**PRELIMINARY AND
FINAL DRAINAGE PLAN
PUD/SP**

22-003

**CREEKSIDE SOUTH AT
LORSON RANCH FILING NO. 2**

MAY, 2022

MAP POCKET

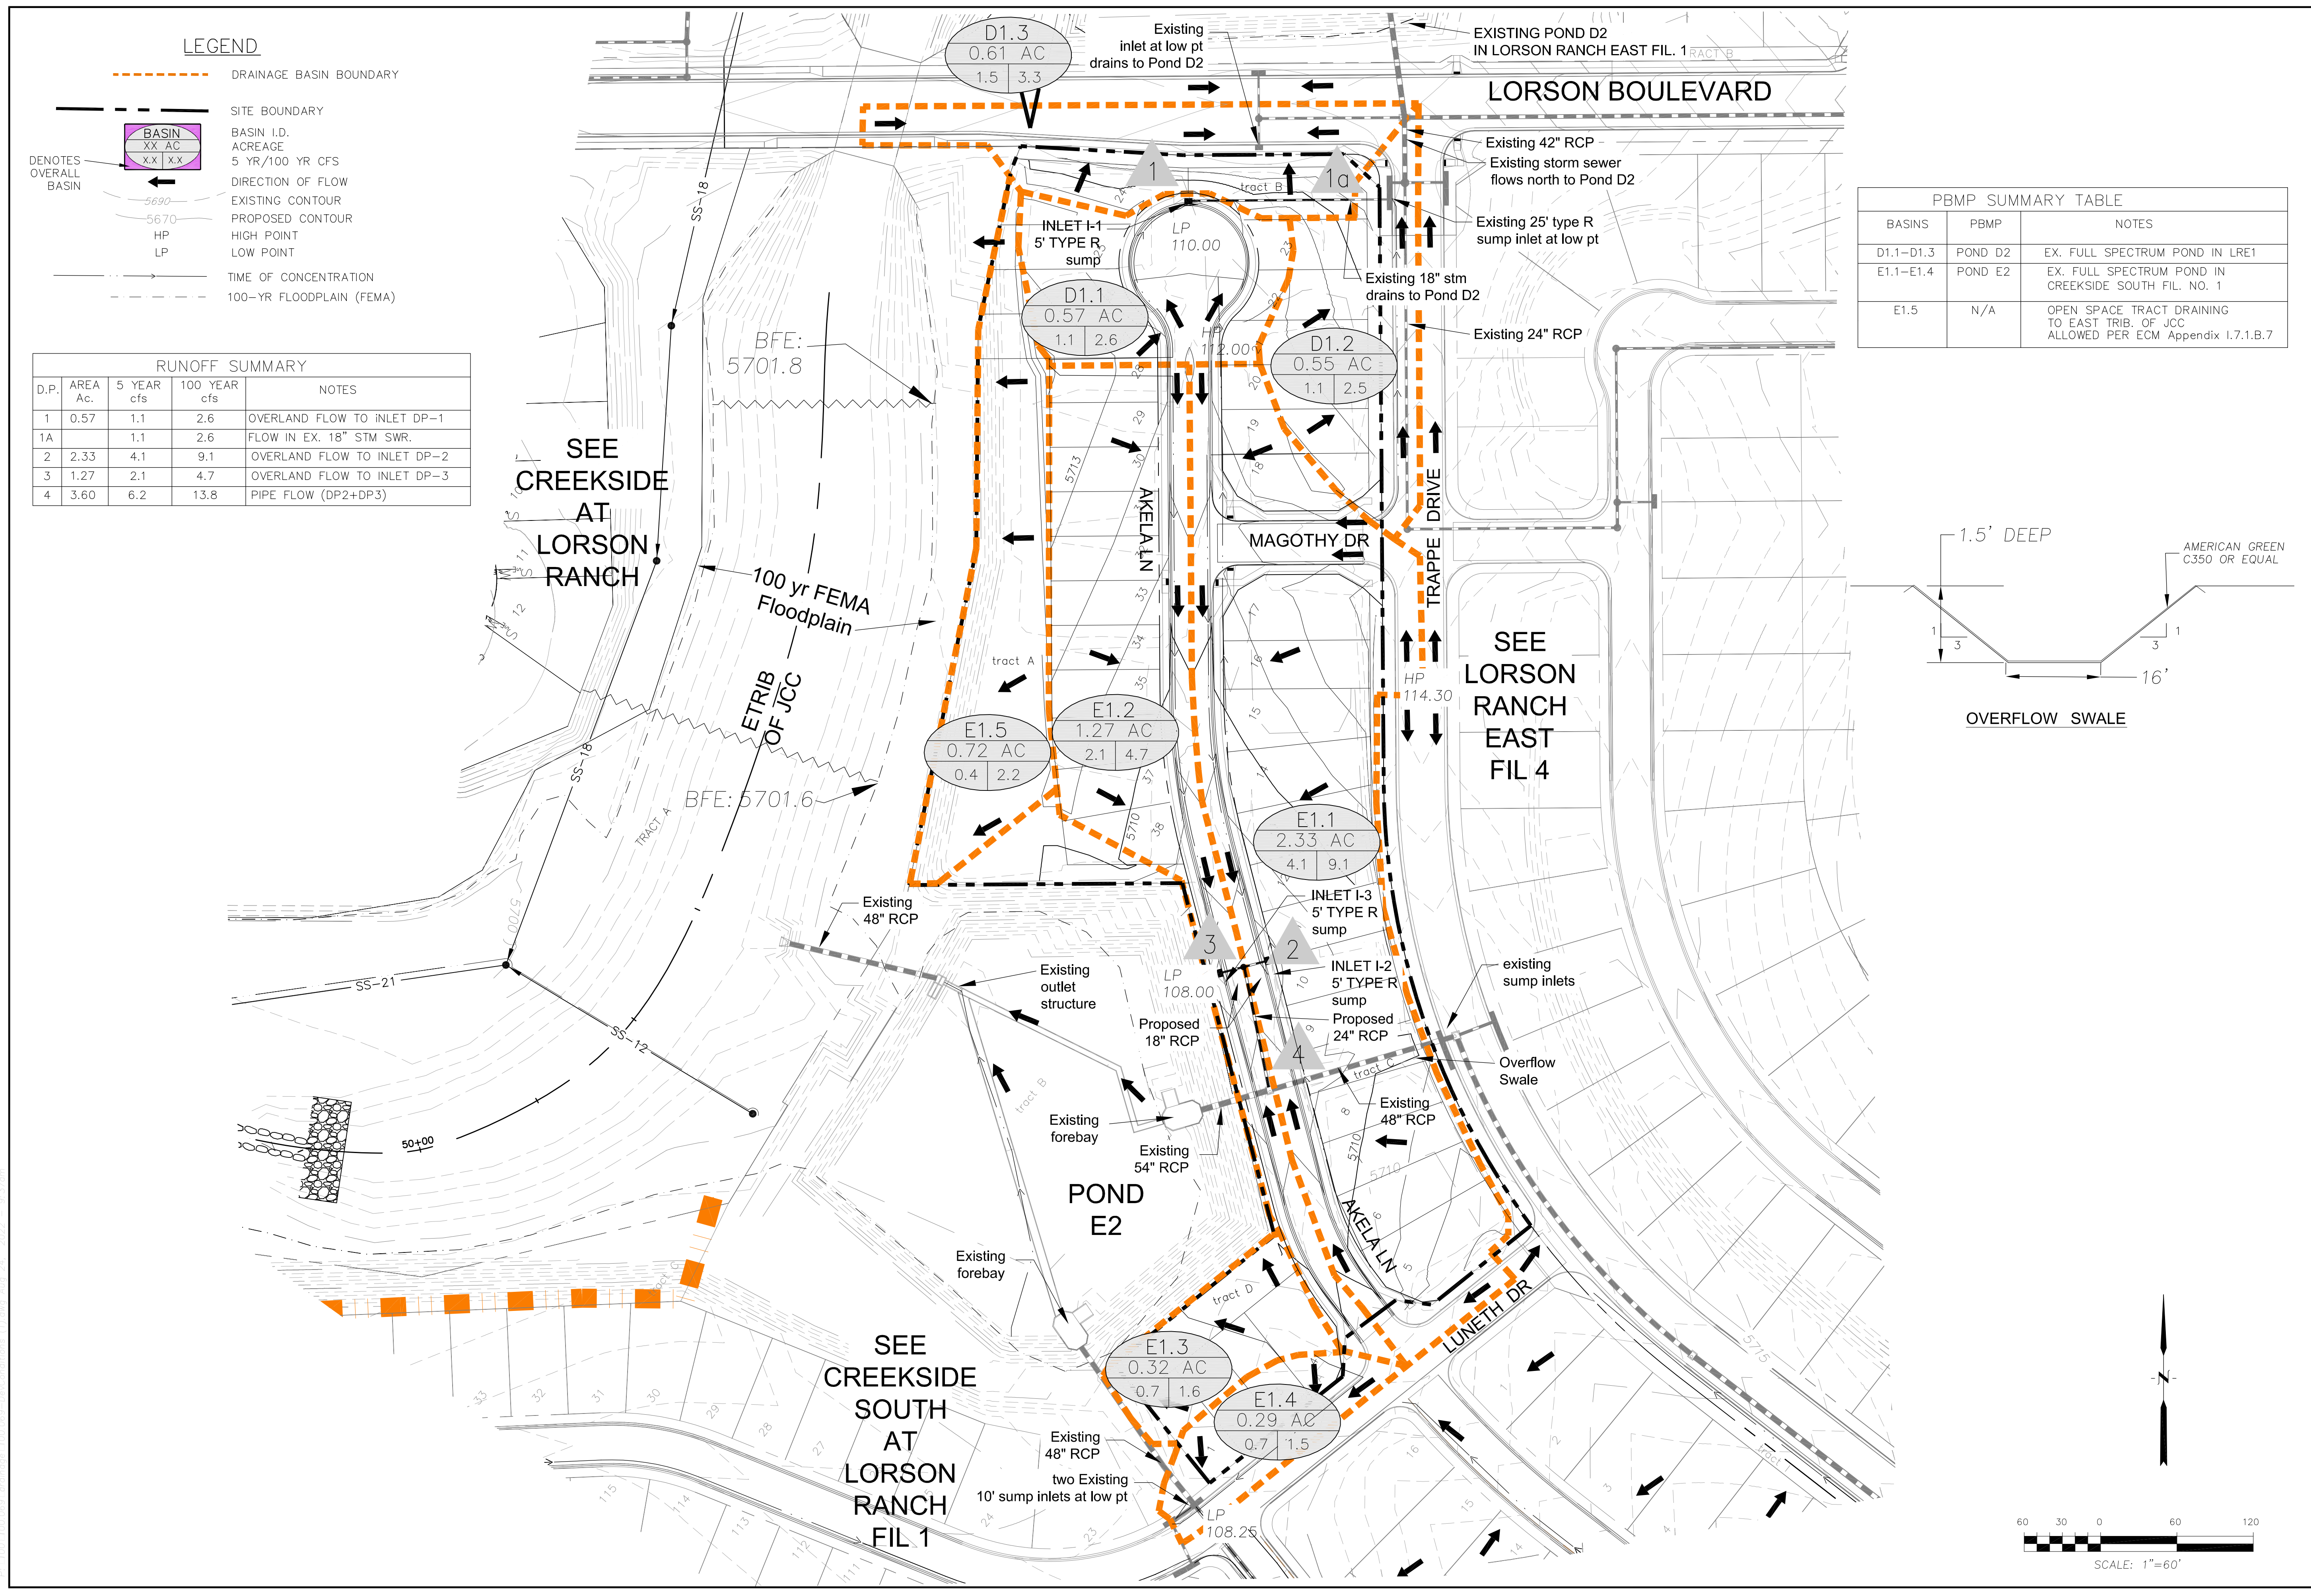
Author: CDurham Subject: Text Box Date: 6/1/2022 10:44:11 AM
Flow arrows show this basin being directed towards the east & north, existing inlet in Trappe Dr

Per my comment on the drainage map, add paragraph(s) for all areas within the F2 limits to show that WQ treatment is accounted for throughout.

Per my comment on the drainage map, add paragraph(s) for all areas within the F2 limits to show that WQ treatment is accounted for throughout.

Author: RSchindler Subject: Sticky Note Date: 6/28/2022 4:10:41 PM
revised direction

Author: RSchindler Subject: Sticky Note Date: 6/28/2022 4:12:15 PM
paragraph added
